1 December 2022

Our reference: ENV/08/3/8/14/6/10

**Ivanhoe Estate Stage 1 - (SSD-8903-MOD 5) - Proposed Amendments to Building C1**

BASEMENT 1

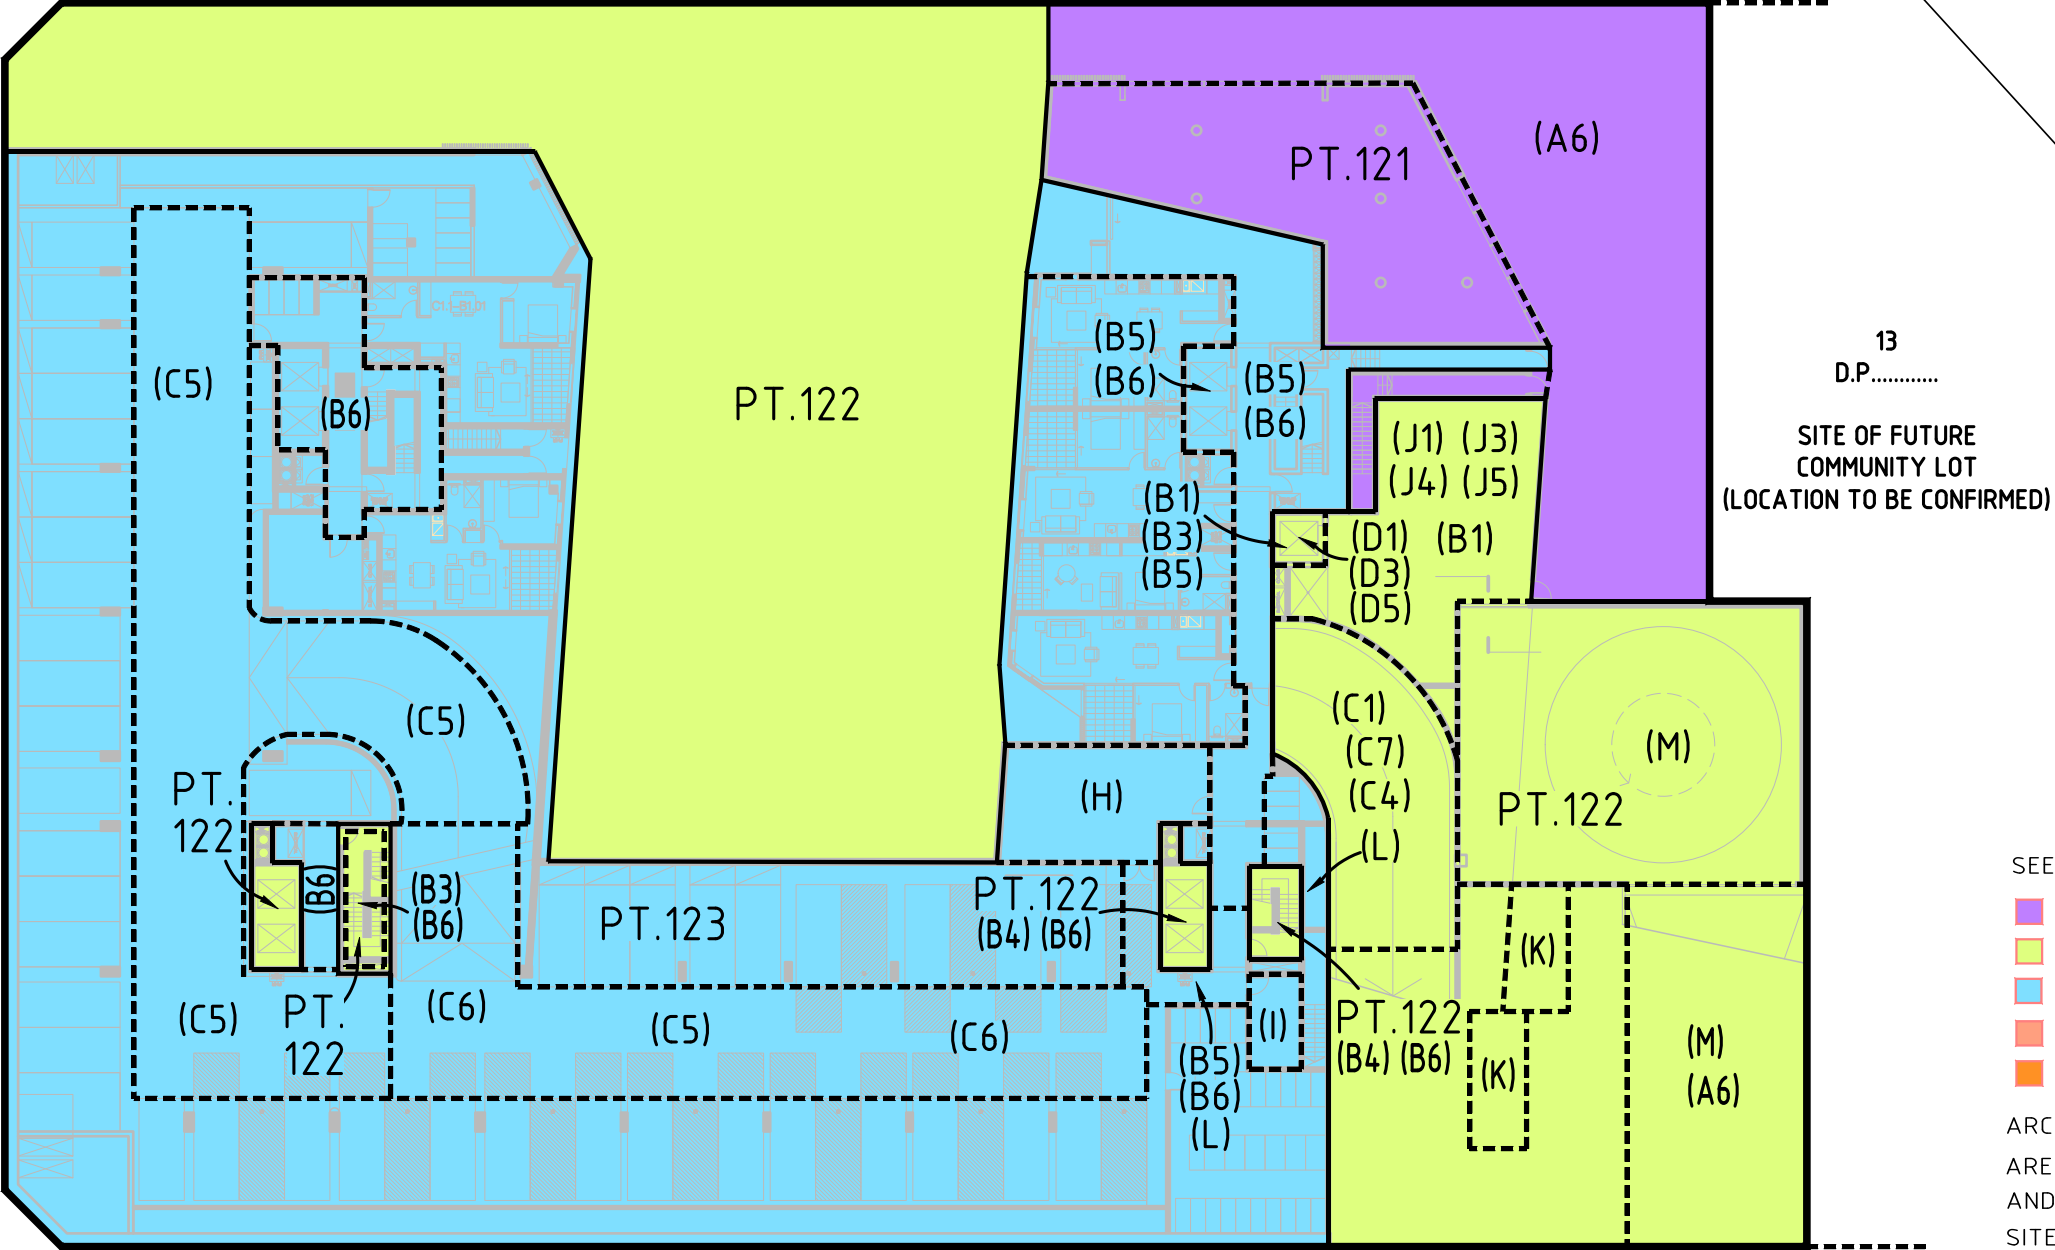
1. Basement 1 plans show proposed amendment in regards to the Exhaust Air Discharge which affects the Waste Loading Dock. Please ensure that this will not impede on the height clearance of the truck and that there will be no exhaust fumes occurring in the loading dock area. A min 4.5m head clearance would be required.
